140 Hope Ave. Lot #7

Via: **Reg Mail**
 RE: **Lot 7 PRP**
 Date: **5-13-04**
 Project No: **959**

From: Jay Reynolds
To: Doug Reynolds
Date: Thu, May 6, 2004 4:08 PM
Subject: PRP III, Lot 7 Review

Drawing Name:	Lot 7 Site and Utility Plan
Project:	PRESUMPCOT RIVER PLACE

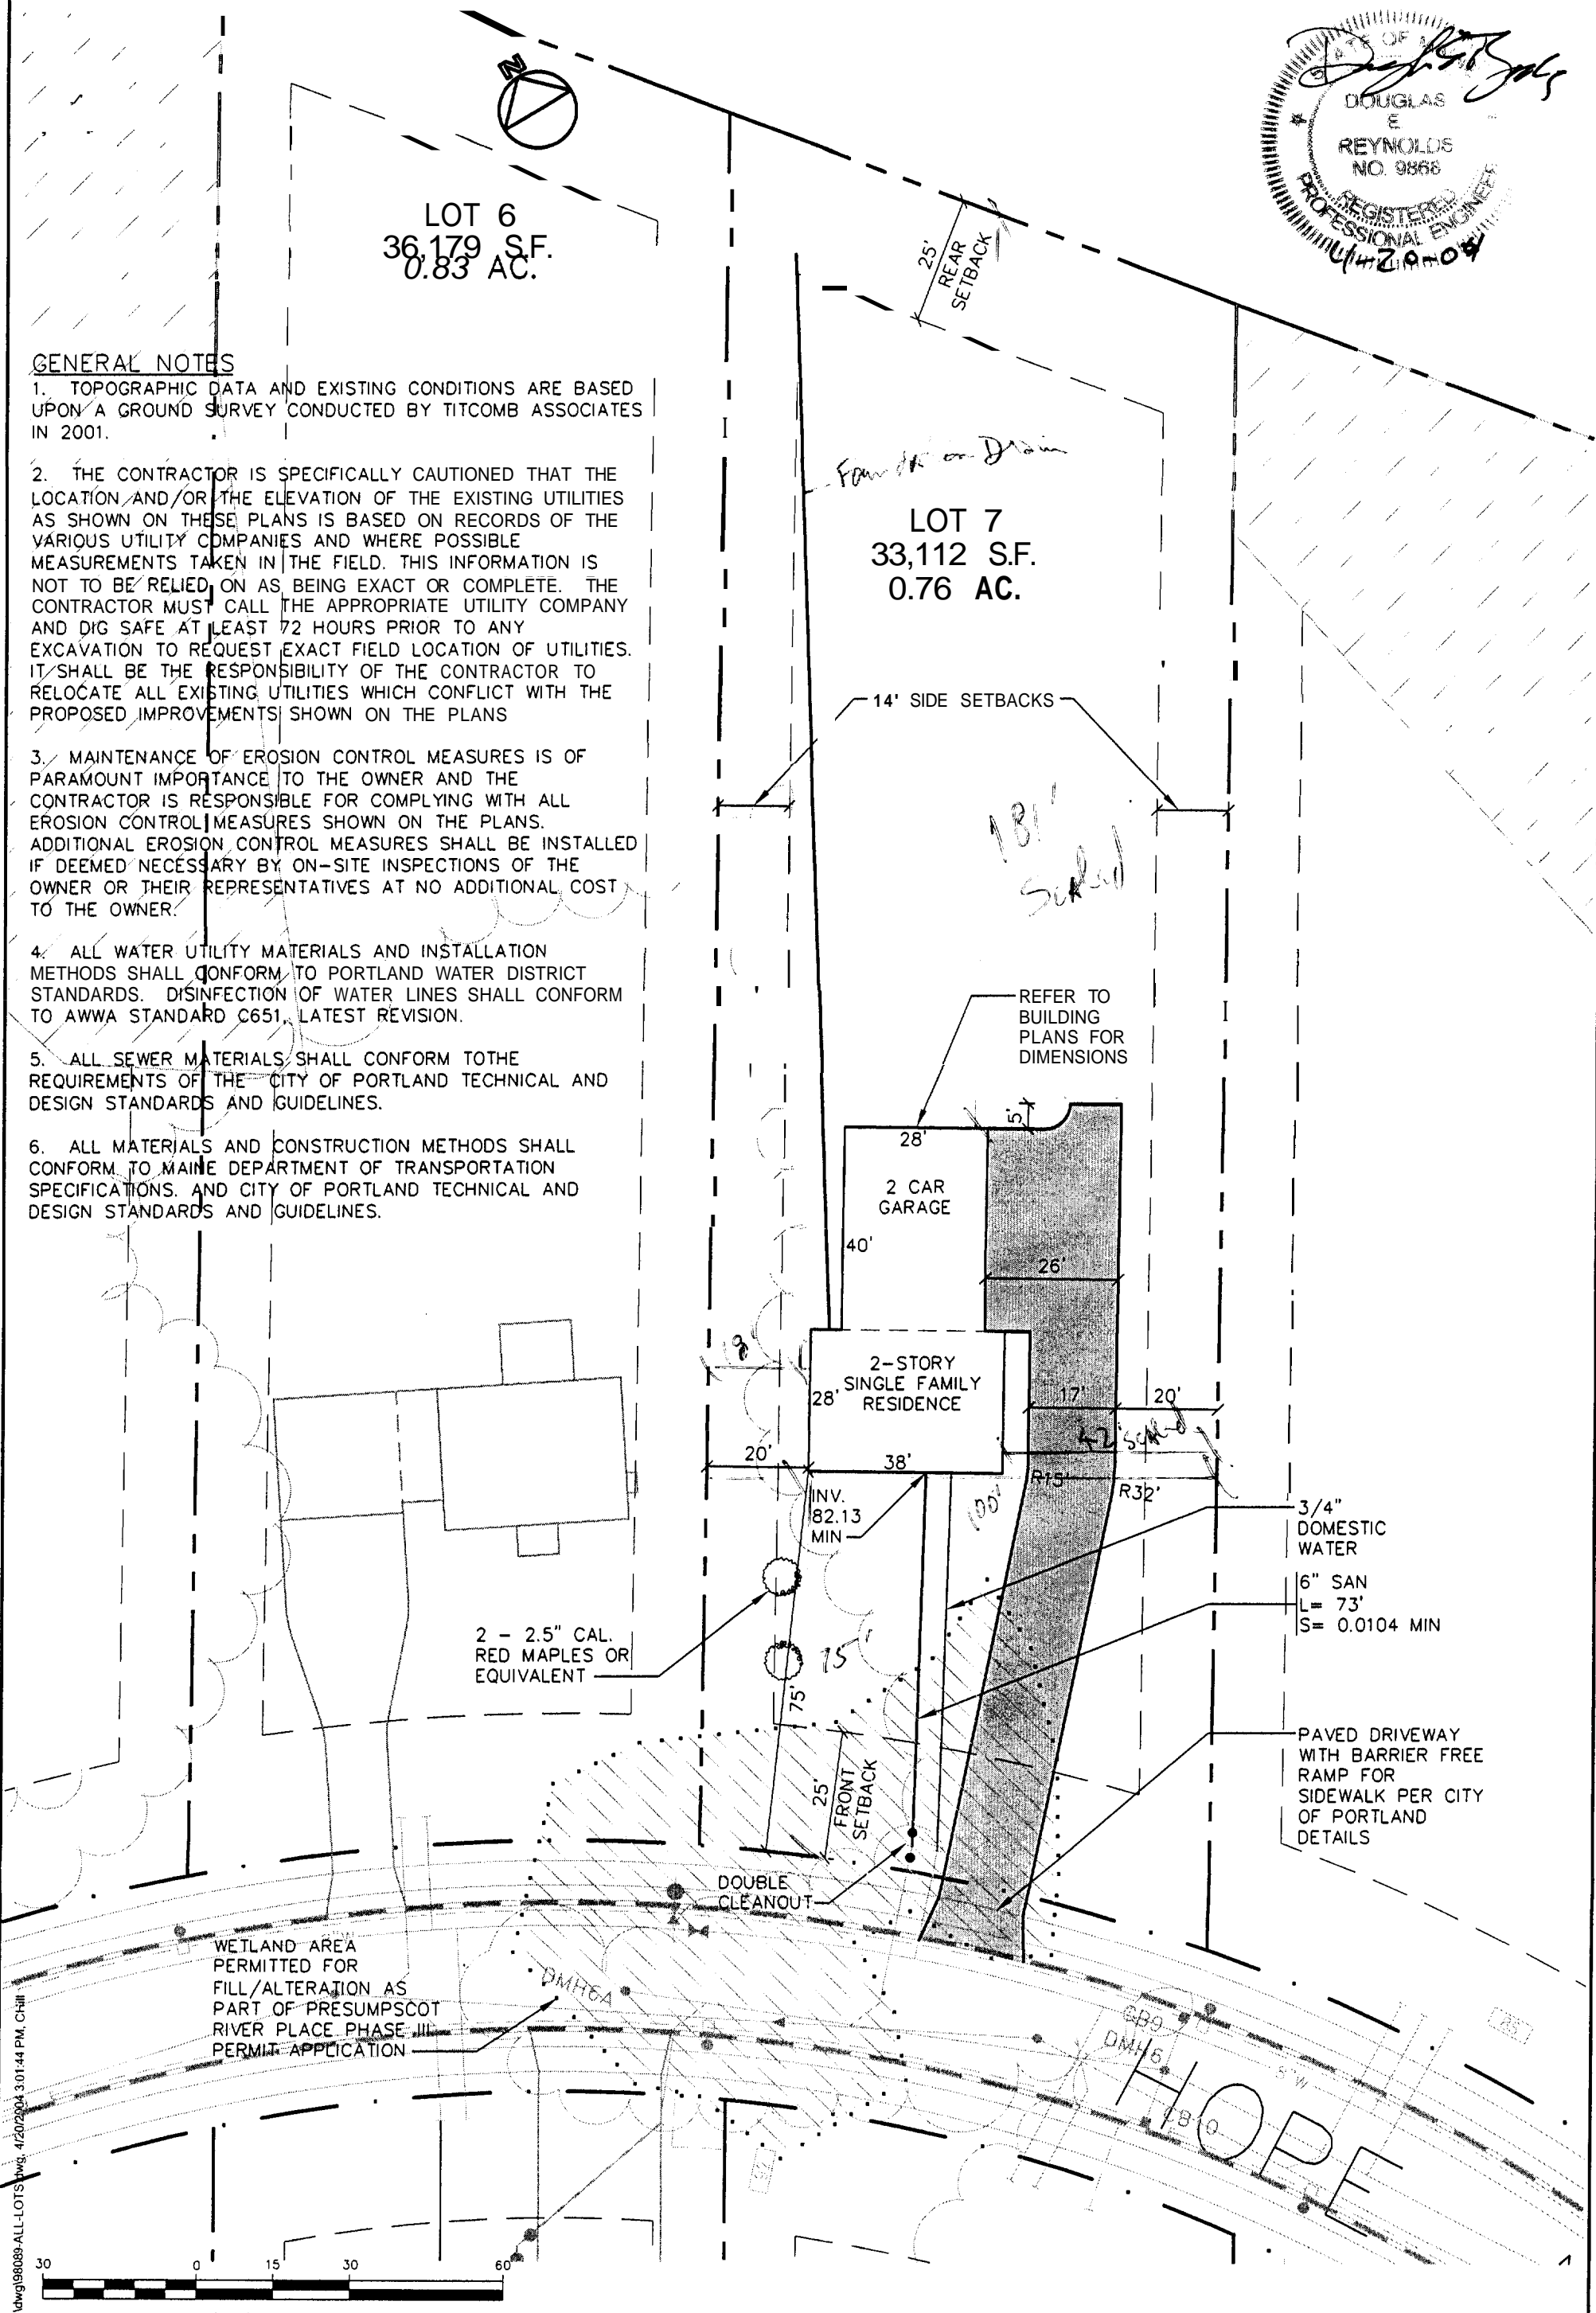
1. The FFE appears to be quite higher than expected. The Subdivision FFE (for gravity sewer) is 89.0, and your site plan indicates 94.5. This is creating some steep sideslopes, and again, will create difficulties when lots 8 and 9 come in. After visiting the site today, I envisioned a FFE equal to lot 6 at 92.75. This looks like a good target elev. to me, and would decrease the impacts and make for a better match-in.
2. Please re-locate the street trees to the right of the driveway (along the street frontage).
3. Please locate the erosion control within the limits of the property.

Remarks:
Jay,
 Attached are revised plans per your email comments for Lot 7
